DEVELOPMENT REVIEW BOARD – SPEED MEMO

DRB CASE NO/PROJECT NO: 1004999

CITY OF ALBUQUERQUE
Planning Department
August 8, 2007
DRB COMMENTS

RE: Tract A, Lands of Glenn Effertz/p&f

**PLAT OF TRACT A
 LAND OF GLEN EFFERTZ
 PROJECTED SECTION 13, T. 10 N., R. 2 E., N.M.P.M.
 TOWN OF ALBUQUERQUE GRANT
 CITY OF ALBUQUERQUE
 BERNALILLO COUNTY, NEW MEXICO
 JULY 2007
 SHEET 1 OF 2**

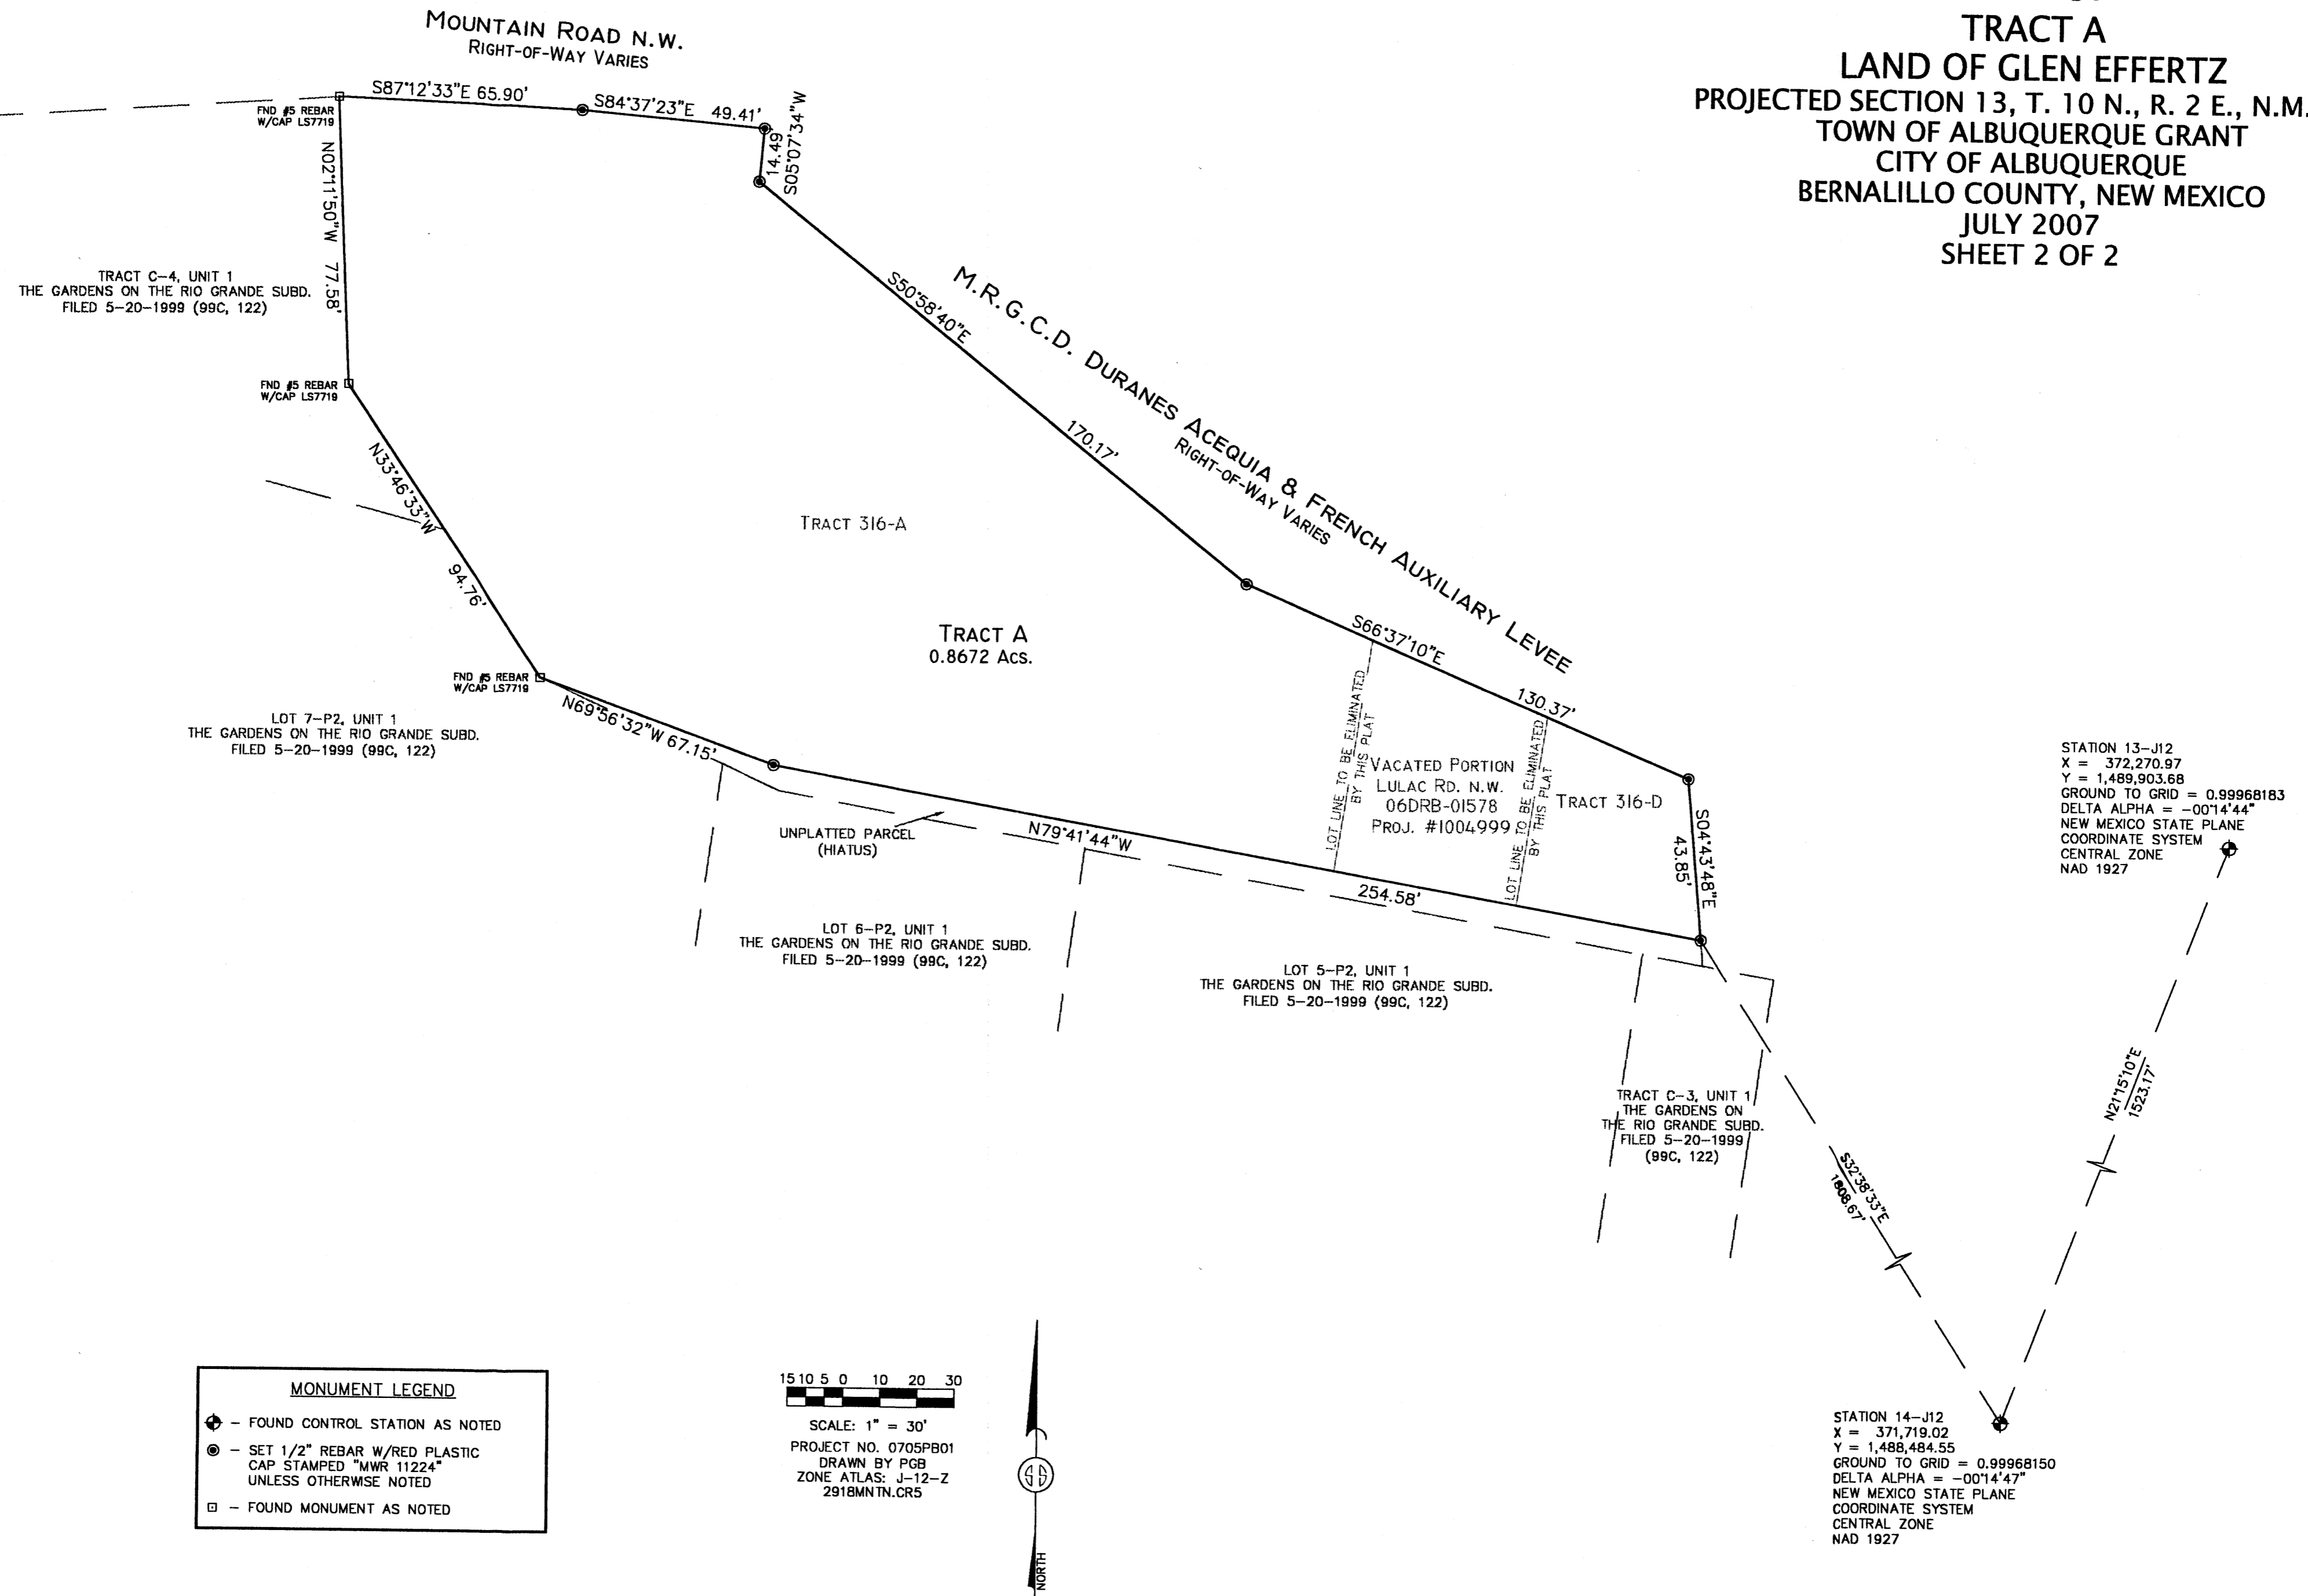
The subject application requires that the plat must contain the following language regarding the installation of solar collectors developed within an area for which DRB approval is sought::

Section 14-14-4-7(B) "No property within the area of requested final action shall at any time be subject to a deed restriction, covenant, or building agreement prohibiting solar collectors from being installed on buildings or erected on the lots or parcels within the area of proposed plat. The foregoing requirement shall be a condition to approval of this plat or site development plan for Subdivision."
